RE: PICTON HIGH SCHOOL RESPONSE TO SUBMISSIONS – RMS COMMENTS

We write with regard to Picton High School Redevelopment (SSD 17_8640), specifically in response to your email dated 12 December 2018 requesting responses to comments raised by RMS following the lodgement of the Response to Submissions package (dated 30 October 2018).

RE: PICTON HIGH SCHOOL RESPONSE TO SUBMISSIONS

: 2500

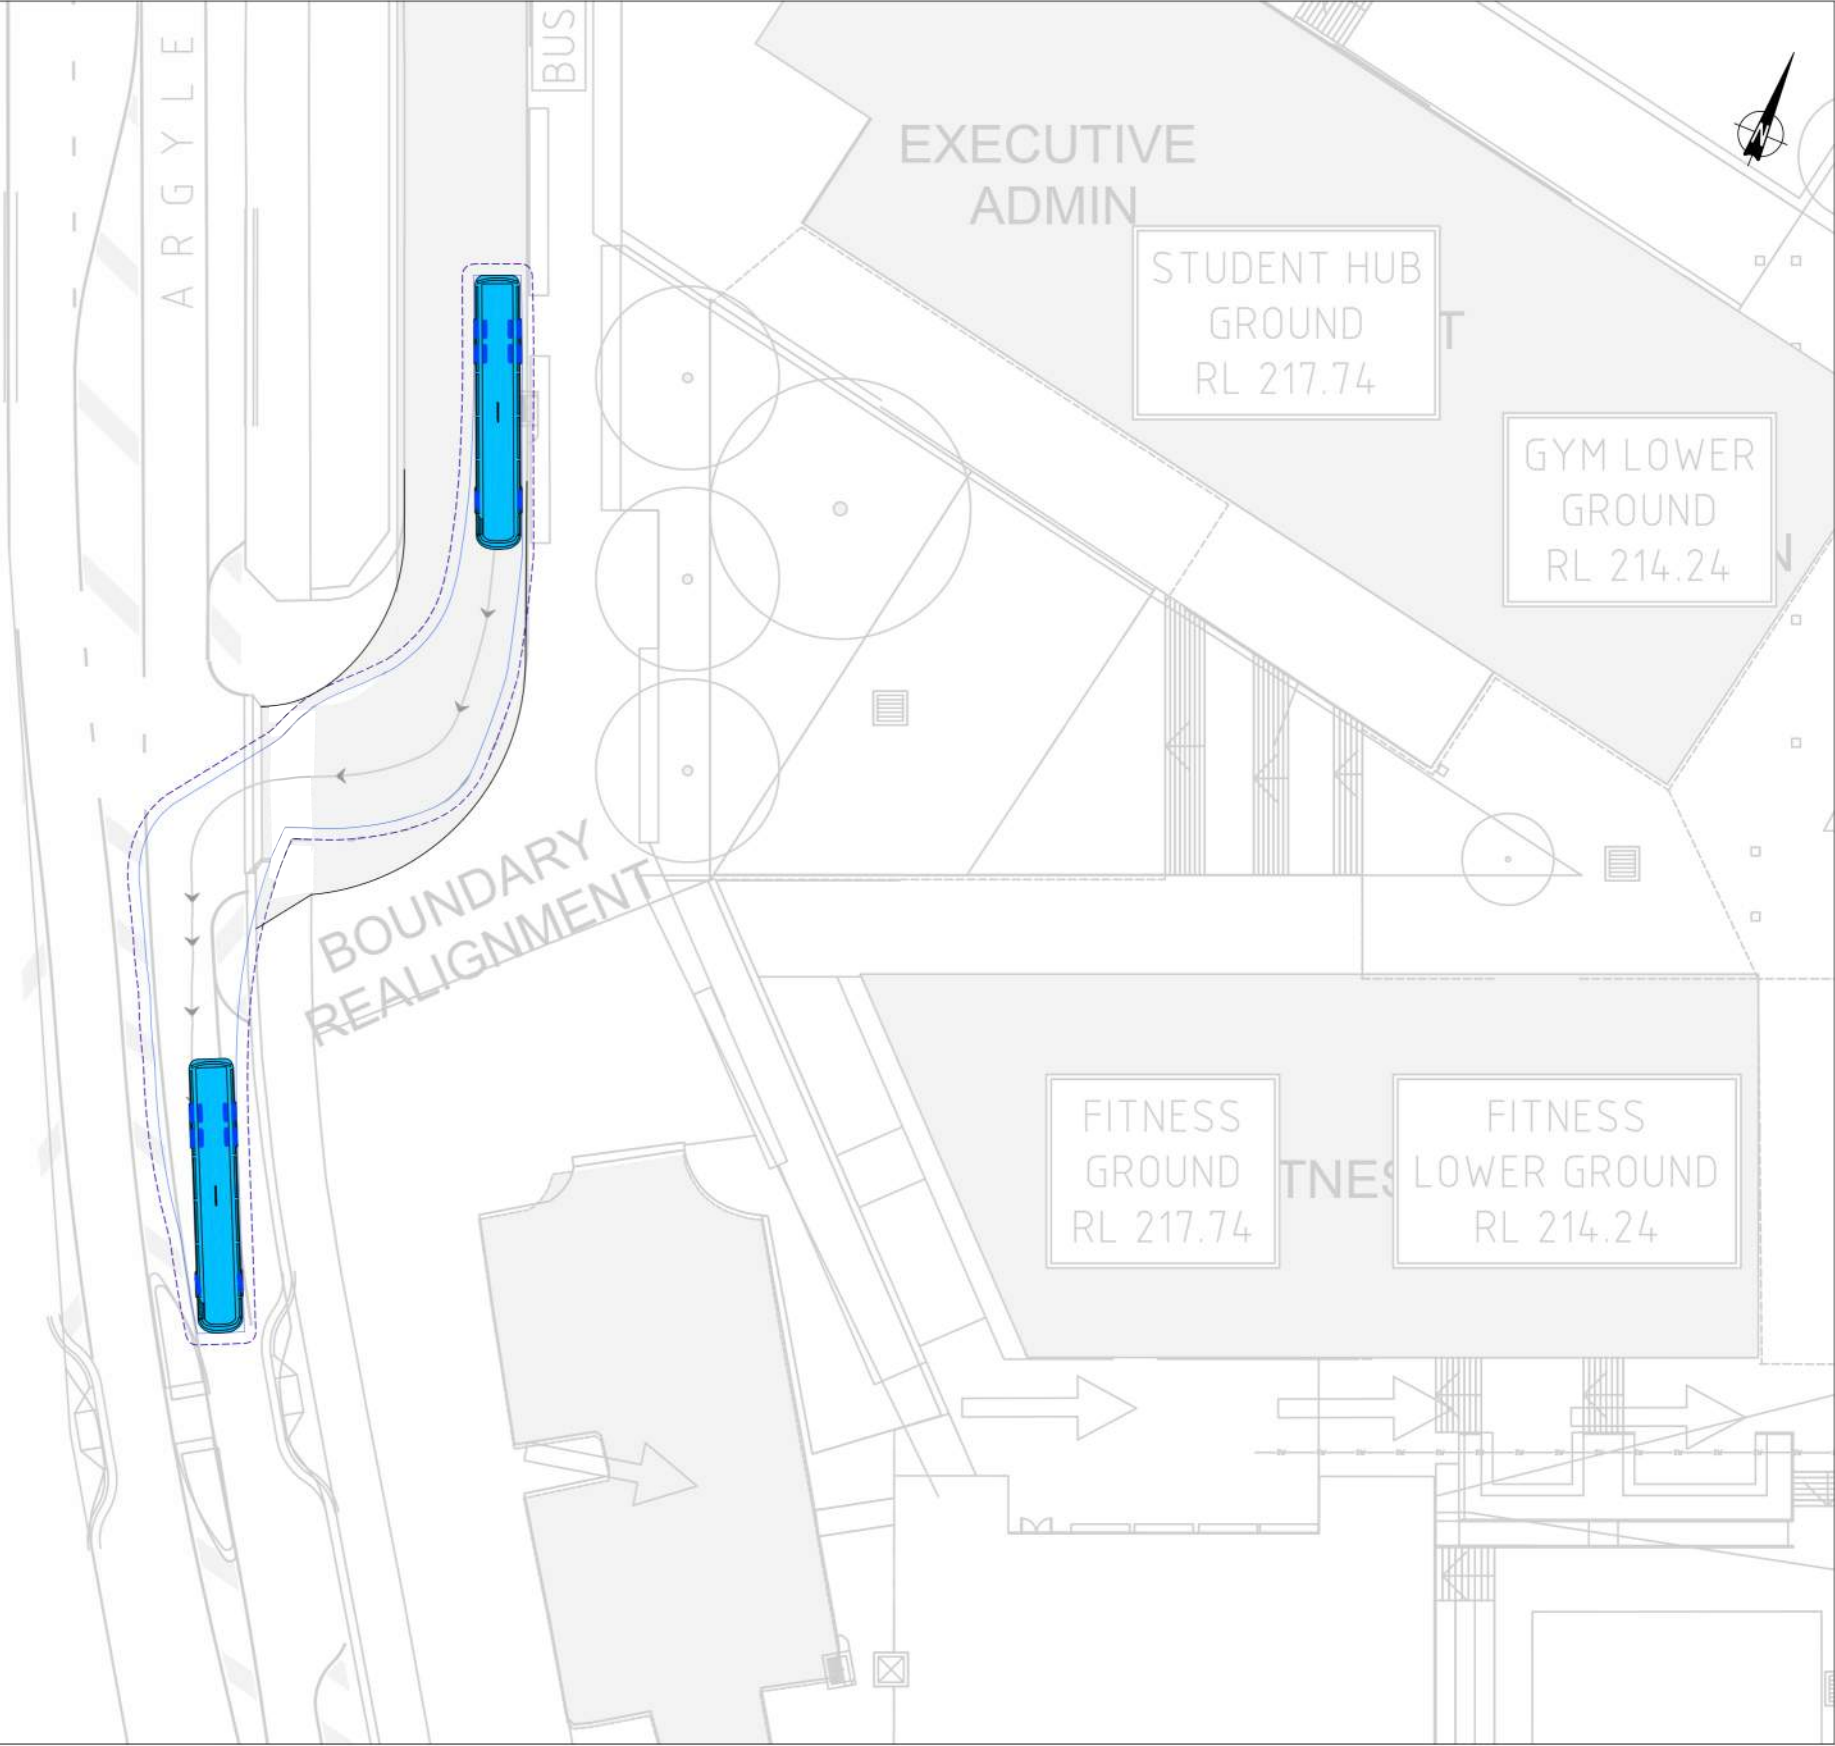
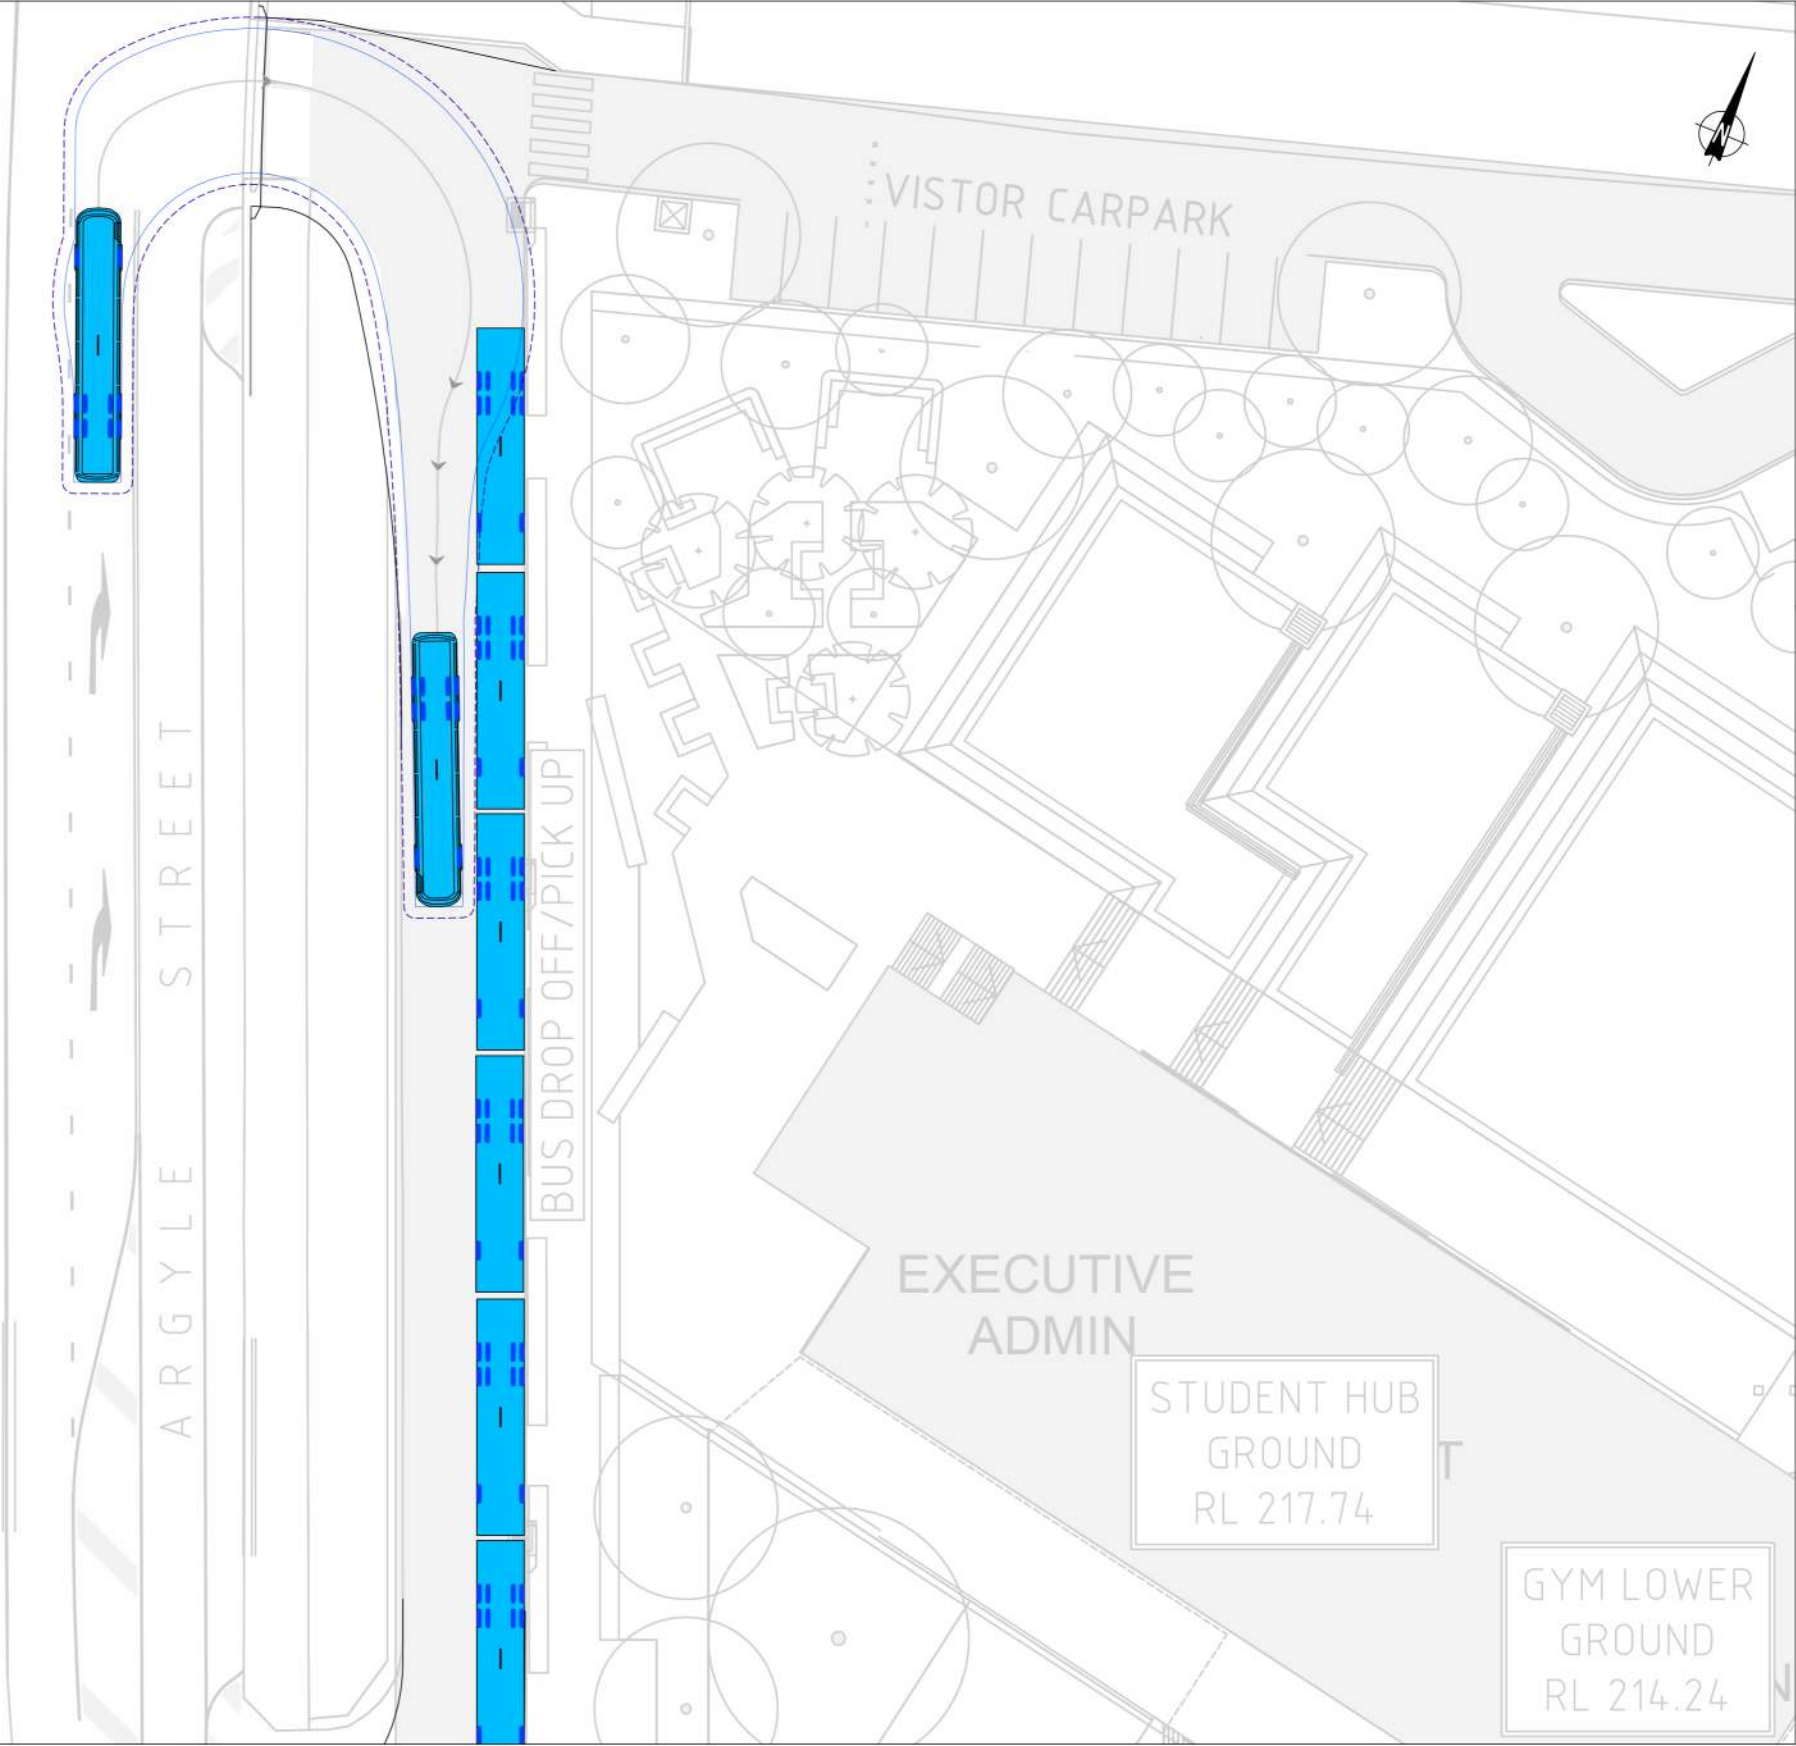
<p>Swept Path Assessment</p> <p>RMS notes that the updated <i>Traffic and Accessibility Impact Assessment</i> (prepared by TDG, Ref: 14584 ta 180803 final, dated 3 August 2018) contains updated turning manoeuvres for buses entering and leaving the site. As detailed in RMS' previous advice the plans provided should comply with Austroads requirements (e.g. speeds used, required clearances, etc). The following comments are provided on the updated plans:</p> <ul style="list-style-type: none"> • The turning path for the bus entering the bus parking area fronting Argyle Street from the north does not appear to have been applied correctly. The radii used are too tight with the vehicle turning at too low a speed. If applied correctly the bus would not be able to park in the last parking space without reversing and manoeuvring into the position; • The bus turning from the right turn bay cannot enter the parking area without the front overhang crossing onto the footpath; • The turning path for the bus exiting the bus parking area to the north has not been applied correctly. The radii used are too tight with the vehicle turning at too low a speed; 	<p>As shown in Attachment B (swept path analysis at 5km/h) this will be the maximum design bus that will be used on-site. The bus access arrangement has been revised to avoid the front overhang.</p> <p>The bus vehicle turning path has been designed in accordance with the 'Austroads 2013 – Design Vehicles and Turning Path Templates Guide'.</p> <p>As specified in the Austroads Guide, the long rigid bus of 14.5 metres long, is designed to a speed of 5km/h.</p> <p>In addition, we have also prepared the bus movement at a design speed of 10km/h (refer to Attachment C).</p> <p>The bus operations (loading and unloading of students) will be managed by staff to ensure students get on the correct bus service, and fill up the first bus before proceeding with the second bus.</p>

Issue	Response
<ul style="list-style-type: none"> When the turning paths are applied correctly a bus is unable to enter the bus parking area if another bus is occupying the end parking space. This could cause queuing onto Argyle Street; If the number of buses shown within the Argyle Street bus pick up/drop off area are to be contained within this area then they would have to exit in the same order as they arrive (i.e. no space between the buses to allow them to manoeuvre into or out of their space if other buses are occupying the adjacent spaces). This has the potential to cause congestion which will impact upon the operation of Argyle Street; <p>Noting the comments above RMS believes that the applicant should be requested to provide the above detail to council for review and comment prior to the determination of SSD 8640.</p>	
School Zones	
<p>RMS notes that the RTS covering letter prepared by Ethos Urban (dated 30 October 2018) details, in part, that the determination of the school zones required (i.e. new school zone and/or amendments to the existing school zone) will be addressed following approval of the current SSD application. While this is correct, it has now become apparent that a temporary school is being established on the site with access to be gained from Wonga Road. The details of the temporary school were not discussed in any detail in the information that has been provided to date. While RMS acknowledges that the temporary school does not form part of the current SSD application, if it is intended to occupy the temporary school at the start of the 2019 school year RMS advises that the new school zone for Wonga Road and associated speed zone reductions will need to be in place before the commencement of use of the temporary school. The new school zone in Wonga Road to be determined in consultation with RMS's Road User Safety Project Officer. It is therefore requested that DPE inform the applicant that they should make contact with Amanda Priestley at RMS on 4221 2517 to further progress the new school zone that will be required in Wonga Road to service the proposed temporary school.</p>	<p>Stephen Craig from Taylor Construction has contacted Amanda Priestley regarding the School Zones on Wonga Road (refer to Attachment D). A concept School Zone plan has been prepared (refer to Attachment E).</p>
